Consultation Response from KC, Highways Development Management
2020/91918 rear of, 38, Occupation Lane, Dewsbury, WF13 4BP
Reserved matters application pursuant to previous permission no. 2018/93598 for outline application for erection of 3 dwellings
Date Responded:20/08/20
Responding Officer: CNB
Responding Ref:K14-7SE/20

DRG No. CS2/04 SCALE 1:100 @ A1

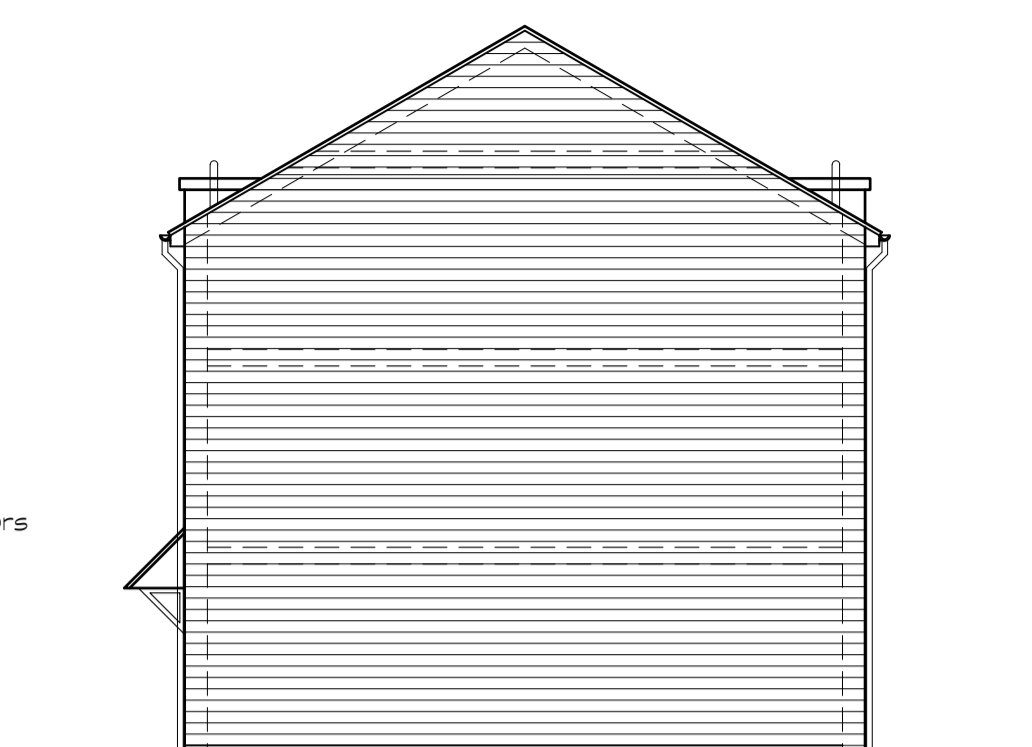
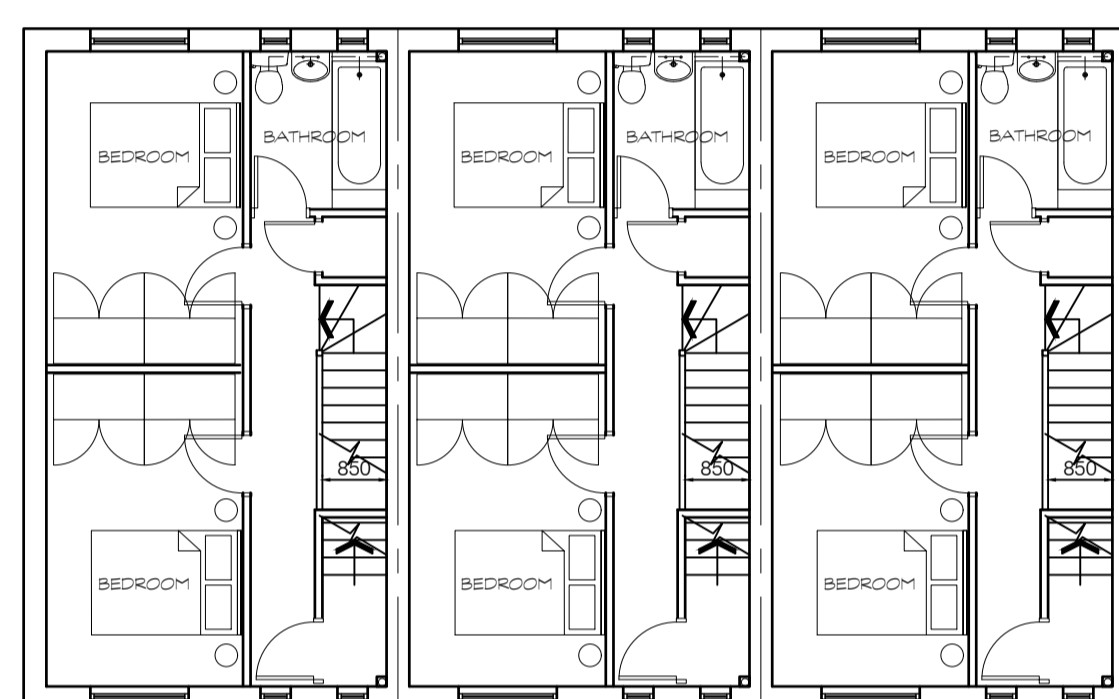
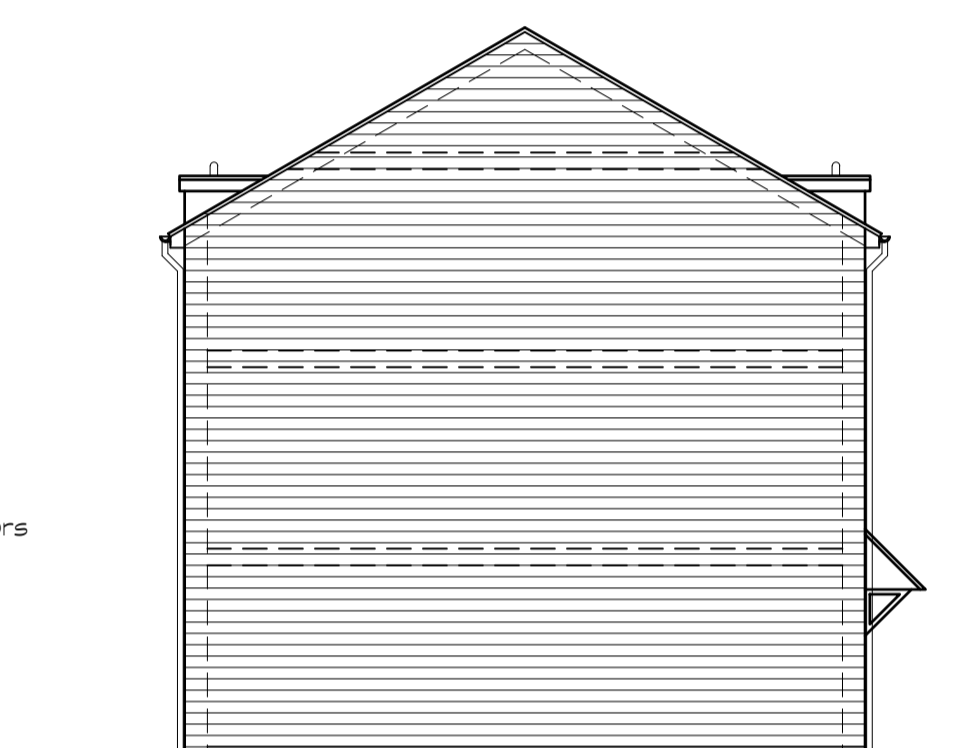
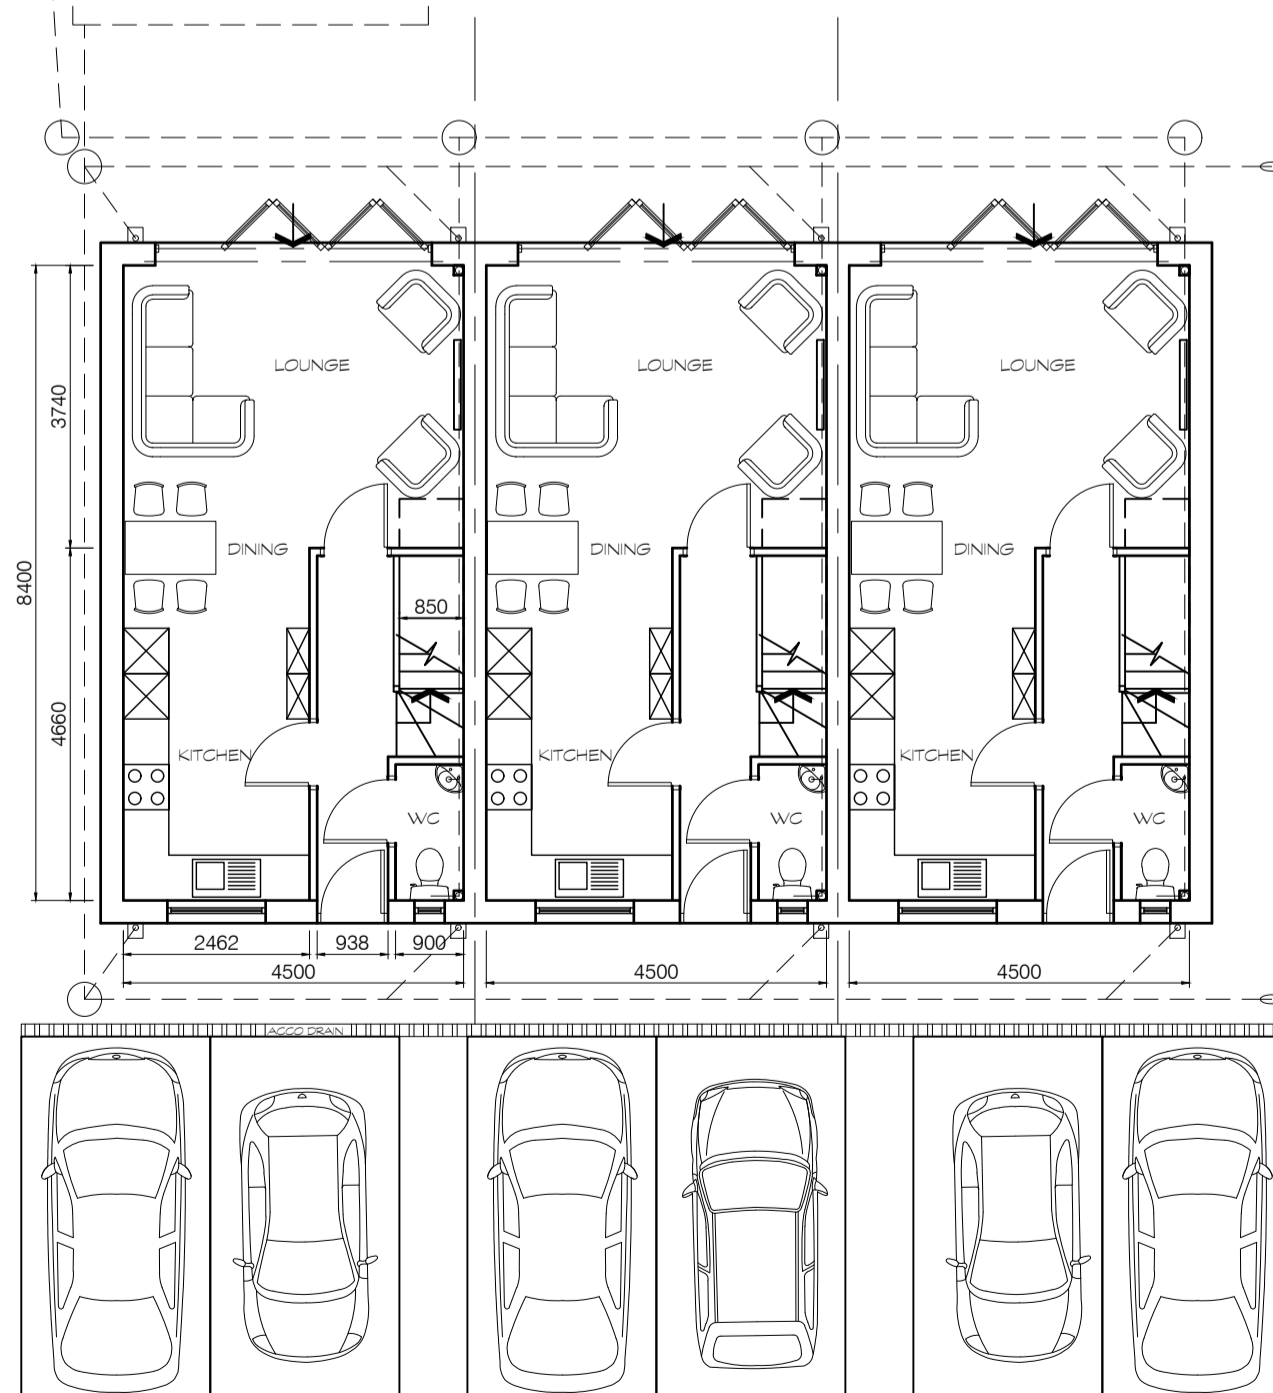
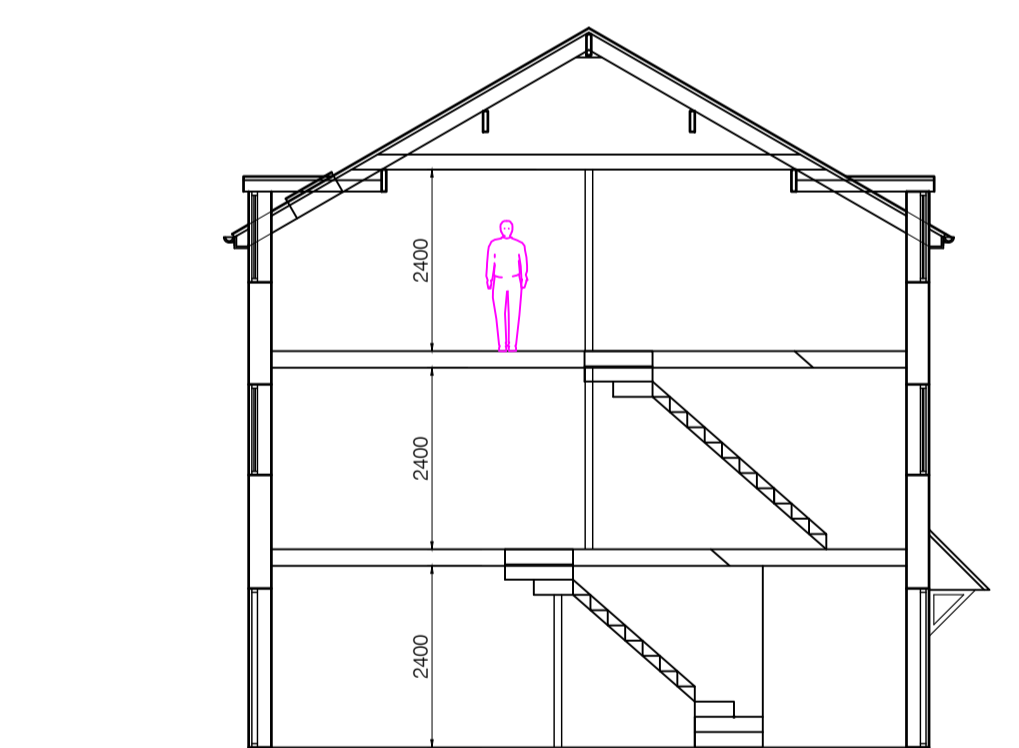
Drawing No CS2/04 indicated that the proposed dwellings are to have four bedrooms and local guidance suggests that for parking to be fit for purpose then each dwelling should have three off street parking spaces. Drawing No CS2/02 indicates only two parking spaces per dwelling and this would be against guidance. No explanation was given as to why this lower level of parking provision has been provided. Application 20/91917 also indicated 4 parking spaces for its proposals within the same parking area and this would be in accordance with guidance as the proposals are for two 3 bed properties being created, although as this would then push the number of dwellings using the spaces above 4 we would also be hoping to see a communal visitor space (as per guidance).

The bin storage locations shown on drawing CS2/04 are suitable for storage only as they are behind a gate and not accessible to a cleansing operative. We would like to see a collection presentation point indicated on the drawing, this should be in such a location that it is accessible to the collection crew but not where it would obstruct the access or footway or highway for road safety reasons. This should be conditioned.

Before development commences, details of suitable storage, bin presentation points and access for collection of wastes from the dwellings hereby approved shall be submitted to and approved in writing by the Local Planning Authority. The approved details shall be provided before first occupation and shall be so retained thereafter.
